**Lane Cove West Data Centre (SSD-9741)
Response to Submissions**

ATTACHMENT 1

Department Comments

Figure 2 – Staging Diagram

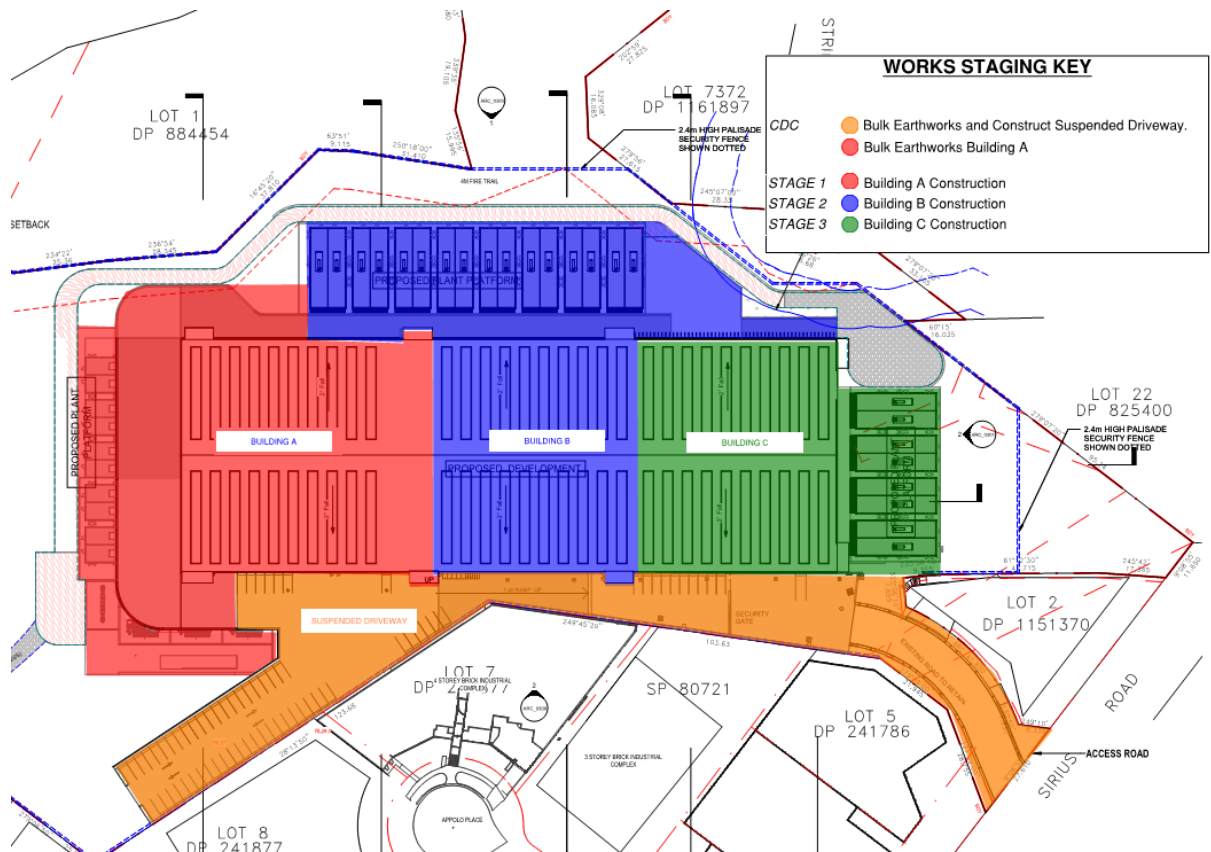
4. The Department notes construction of the data centre would be undertaken in three stages, being:
 - (i) Phase 1 – Bulk earthworks across the site, southern data halls and associated infrastructure, driveways and parking areas and the substation area
 - (ii) Phase 2 – Central data halls and associated infrastructure
 - (iii) Phase 3 – Northern data halls and associated infrastructure.

Given the constrained nature of the site, please provide further detail regarding how construction would be staged to minimise potential conflicts between on-going construction works and the operation of completed data halls. Consideration should also be given to the provision of parking for both construction and operational staff during this period.
